DEVELOPMENT REVIEW BOARD  
SUPPLEMENTAL SUBMITTAL

PROJECT NO. PR-2020-004604

**To:** Jolene Wolfley and DRB Members, City of Albuquerque  
**From:** Michael Vos, AICP, Consensus Planning, Inc. *MV*  
**Date:** January 22, 2021  
**Re:** Allaso Vineyards DRB Comment Responses (PR-2020-004604)

This memo outlines the responses and changes made to the site plan for the Allaso Vineyards project based on the comments received and reviewed at the January 13, 2021 DRB meeting. The comments are numbered and followed by the response in italics.

**6 TYPICAL ACCESSIBLE PARKING STALL**  
SCALE: 1/4" = 1'-0"

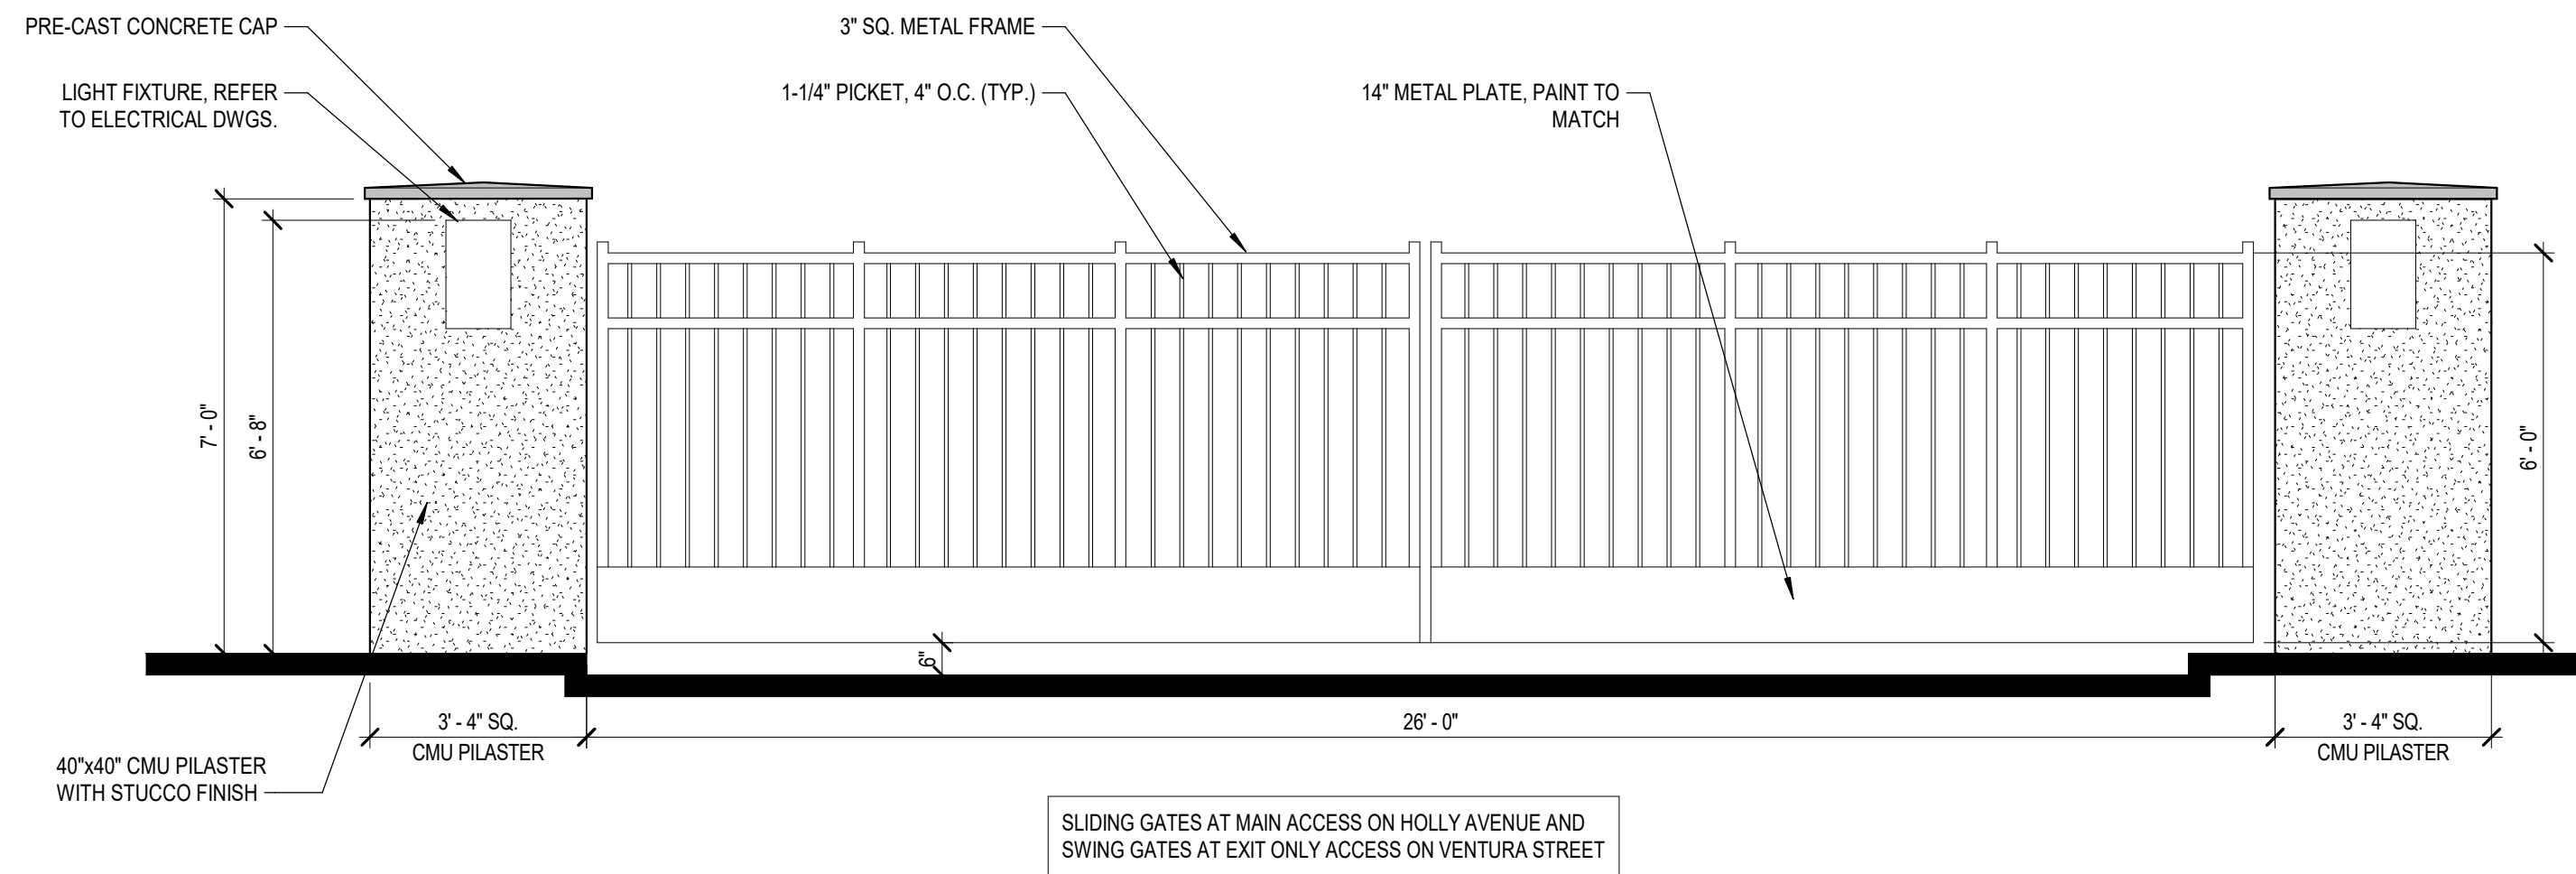
13. Next to the van accessible space, label a minimum of 8 feet for the width of the van accessible aisle.
  - a. Per ADA, the Architect utilizes an 11-foot space with a 5-foot aisle as an alternative to the 8-foot space and 8-foot aisle option. This is clearly show in the typical accessible parking stall detail on sheet A1.20.*

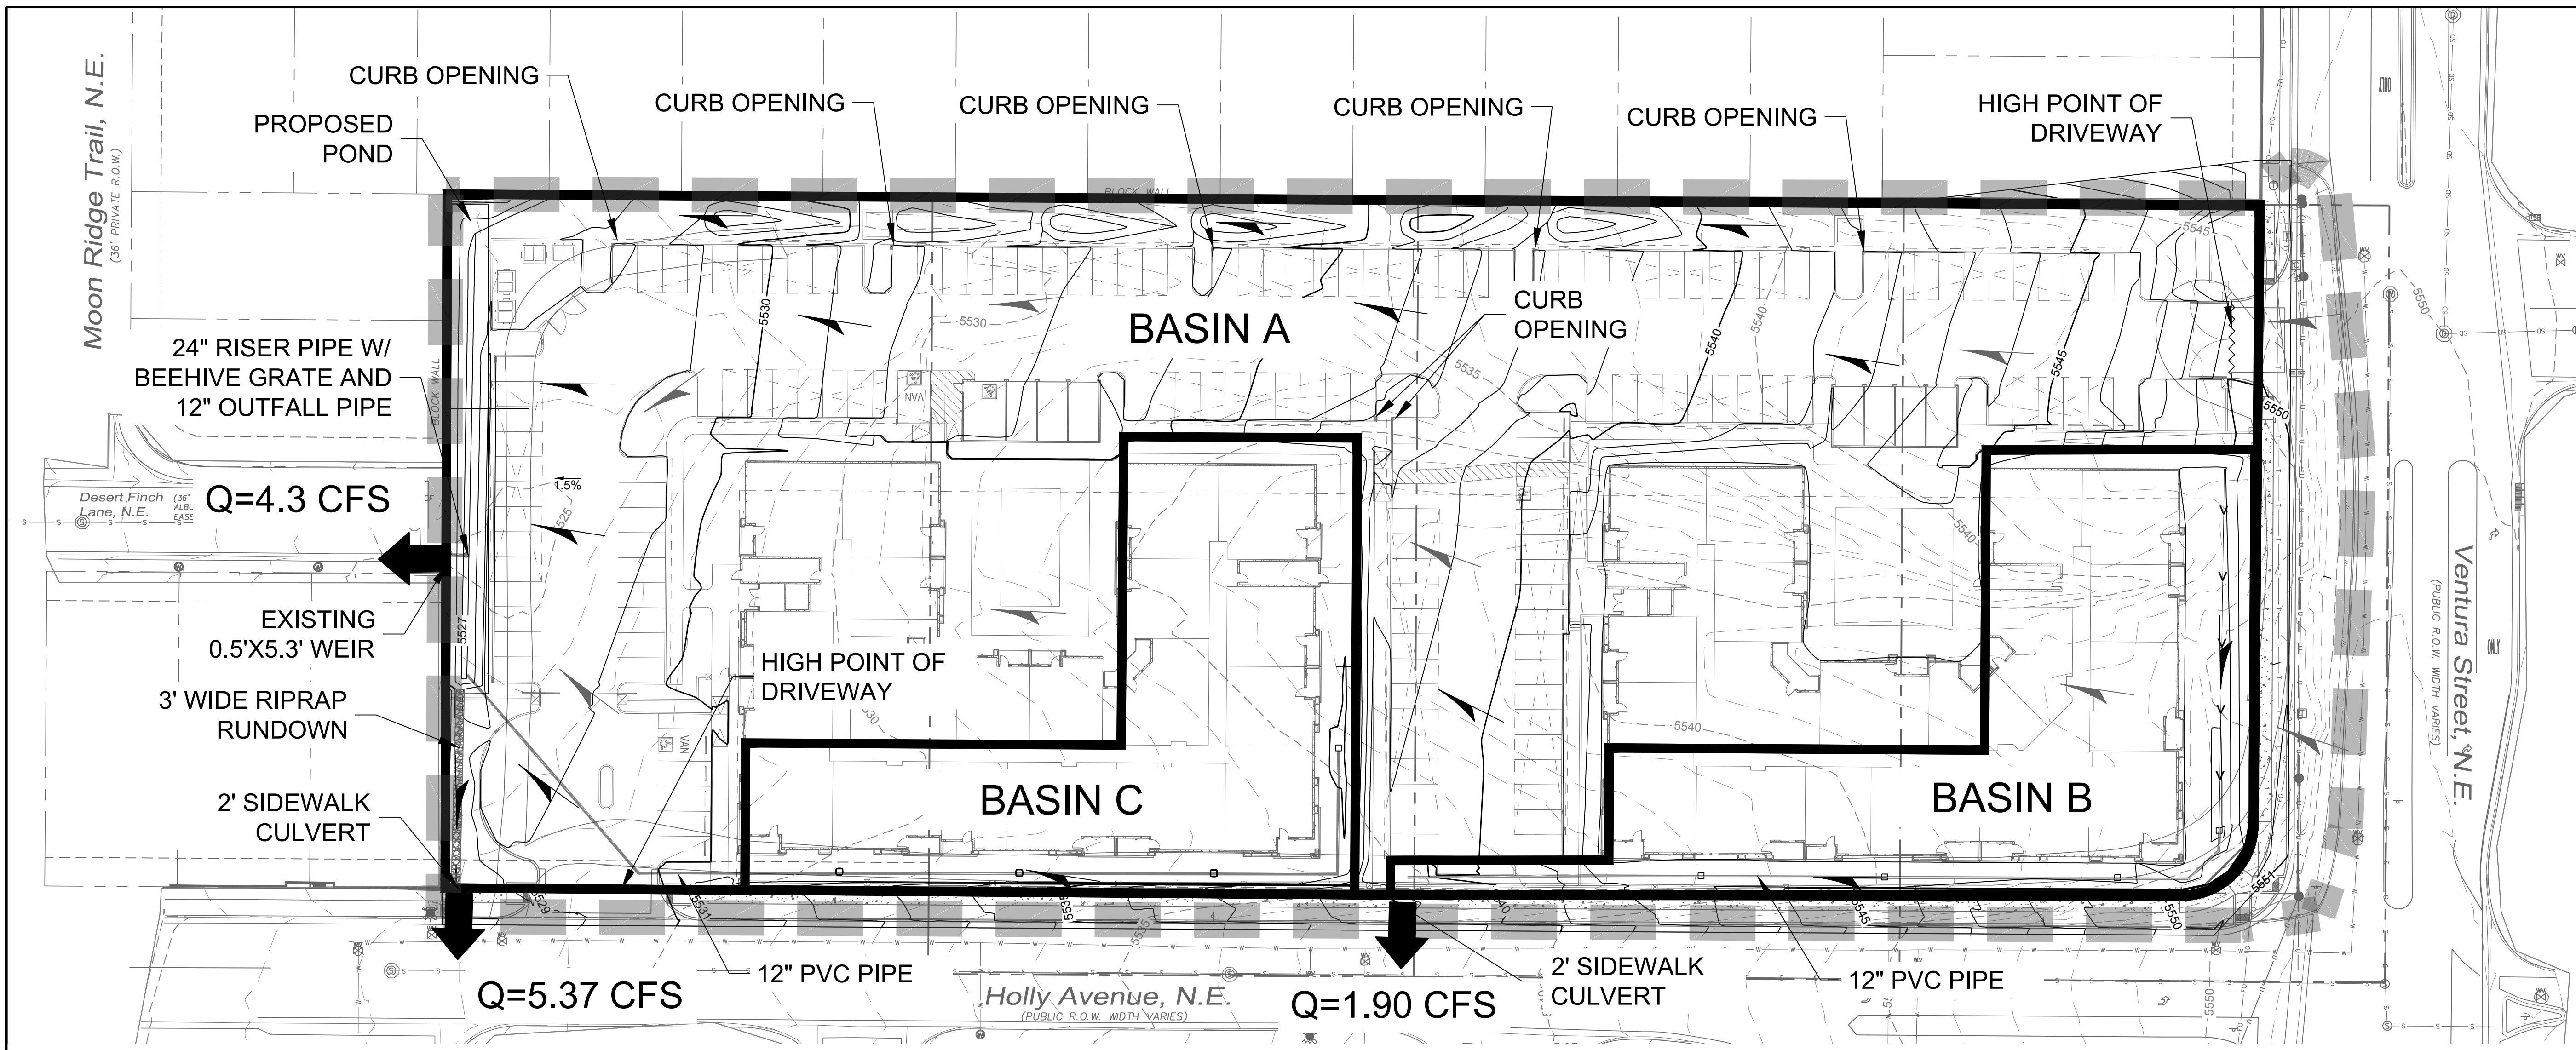
Sheet C-101

1. Stormwater discharges across the sidewalk are not allowed on collector roads and above; provide sidewalk culverts or drain lines through the curb. (See below)

- Please show in more detail as how the proposed 12" PVC will be outfall into the existing mountable curb rundown (see below). A section showing the riser pipe with all needed elevations may be of some help.

**C-105**

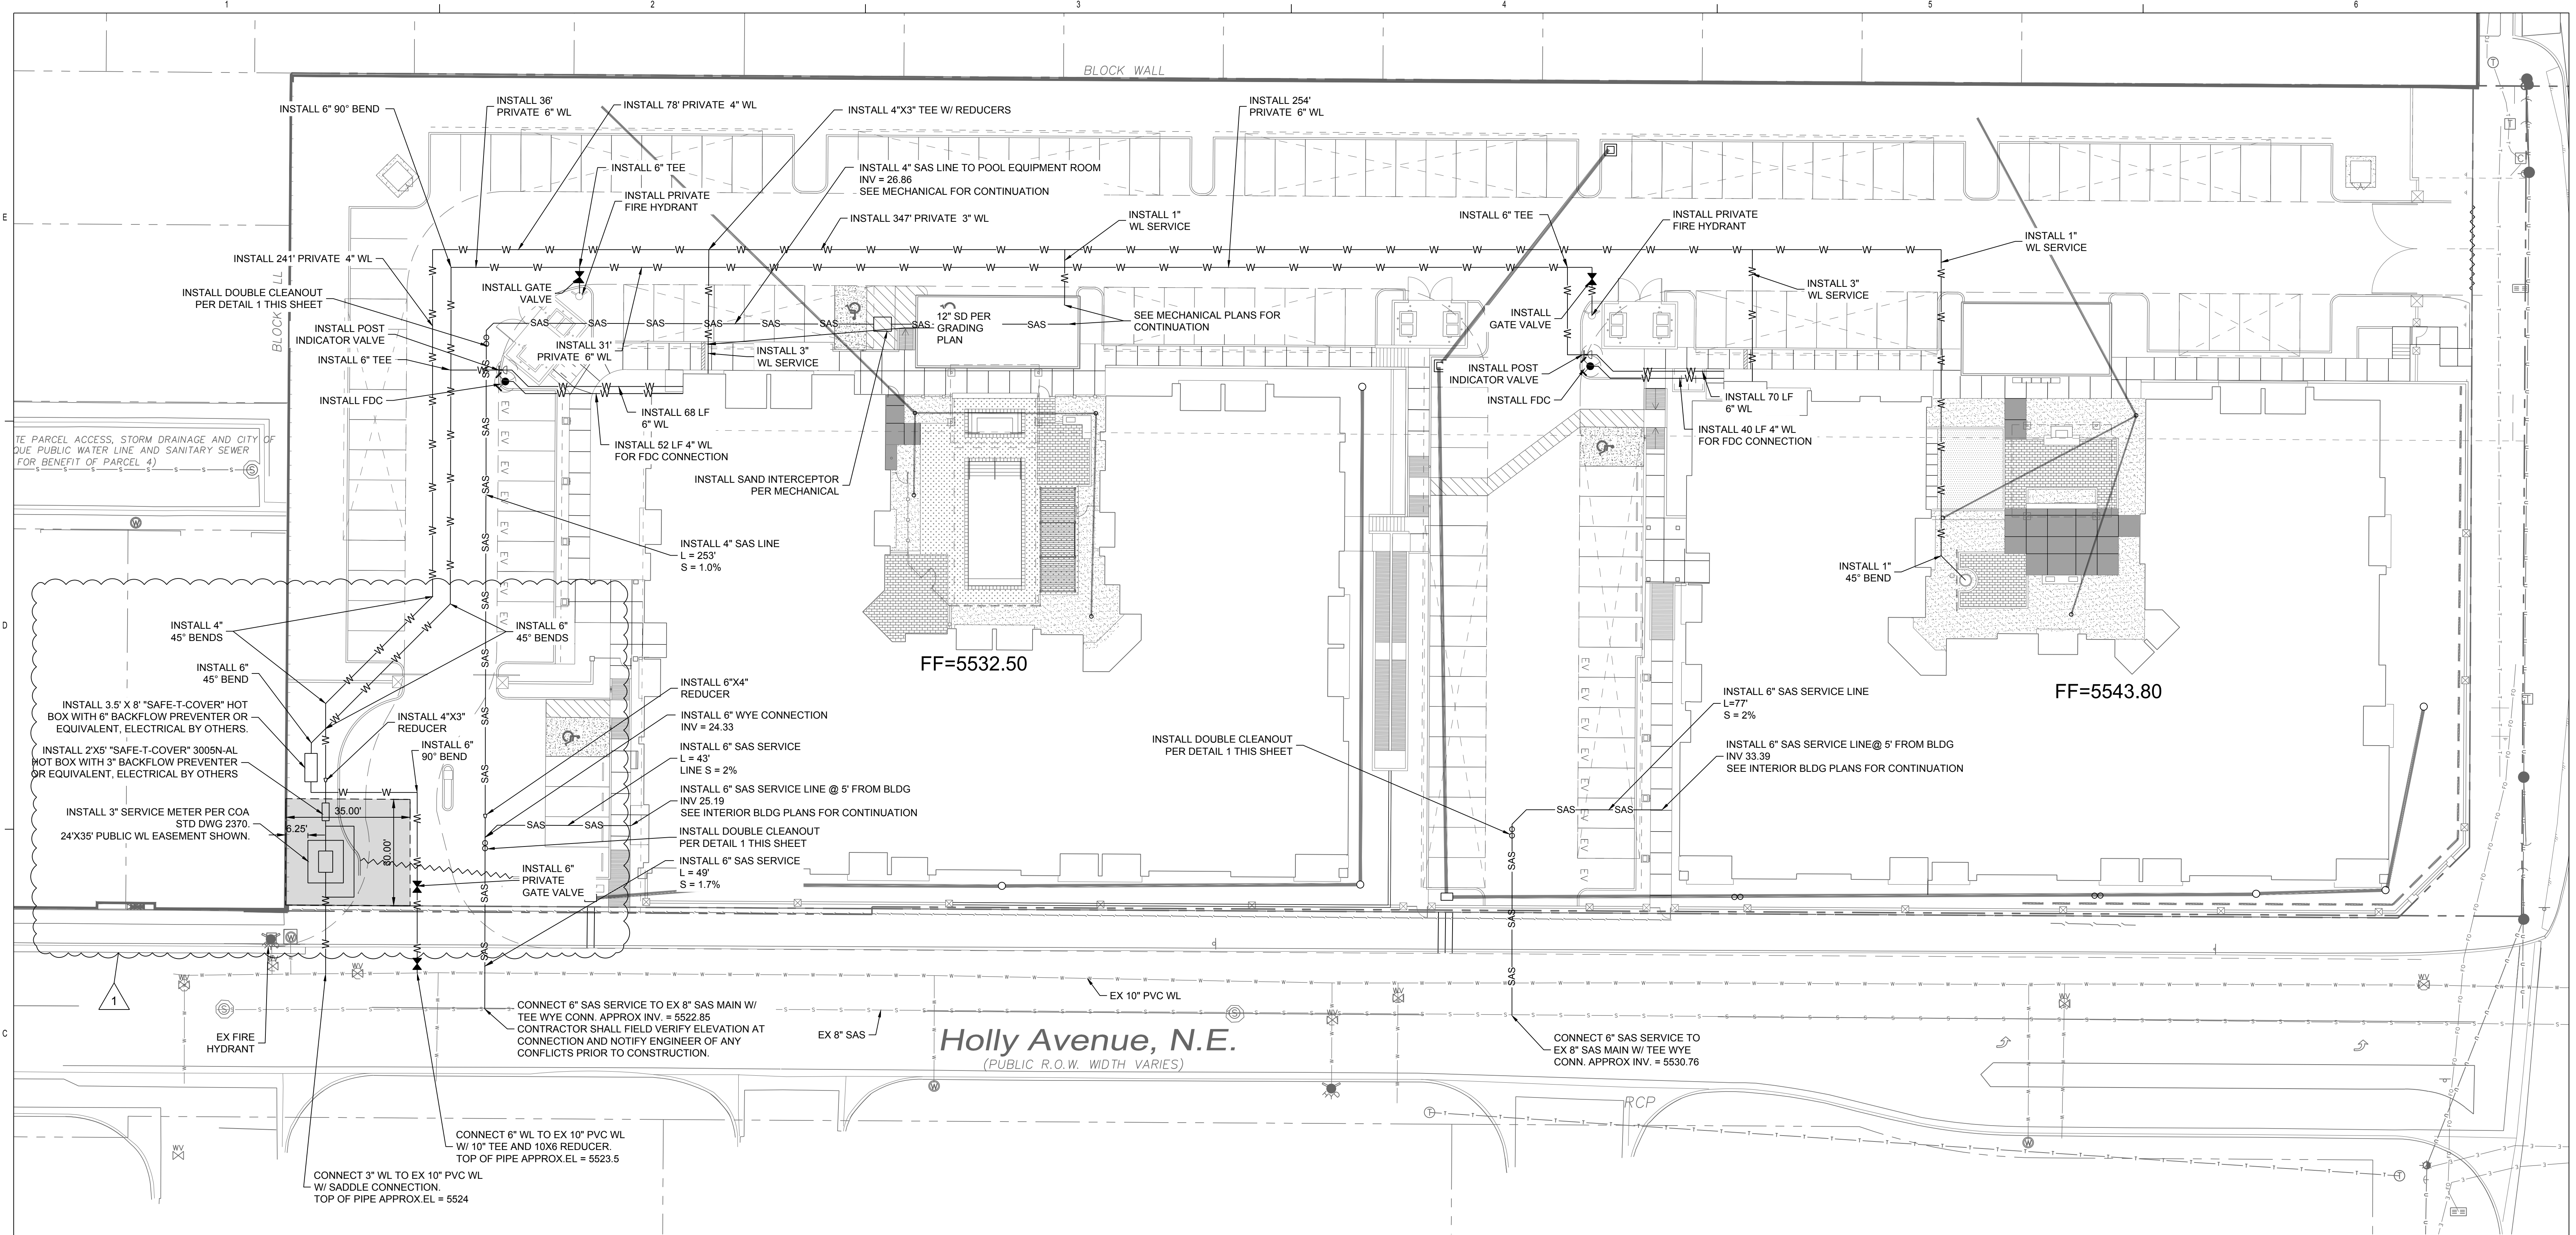
## Sheet C-105

1. Please provide all structural calculations that corresponds with the retaining details to ensure that they will work especially the ones right next to the R.O.W. These calculations can be submitted as a separate document with an engineering stamp and signature & date with the submittal.
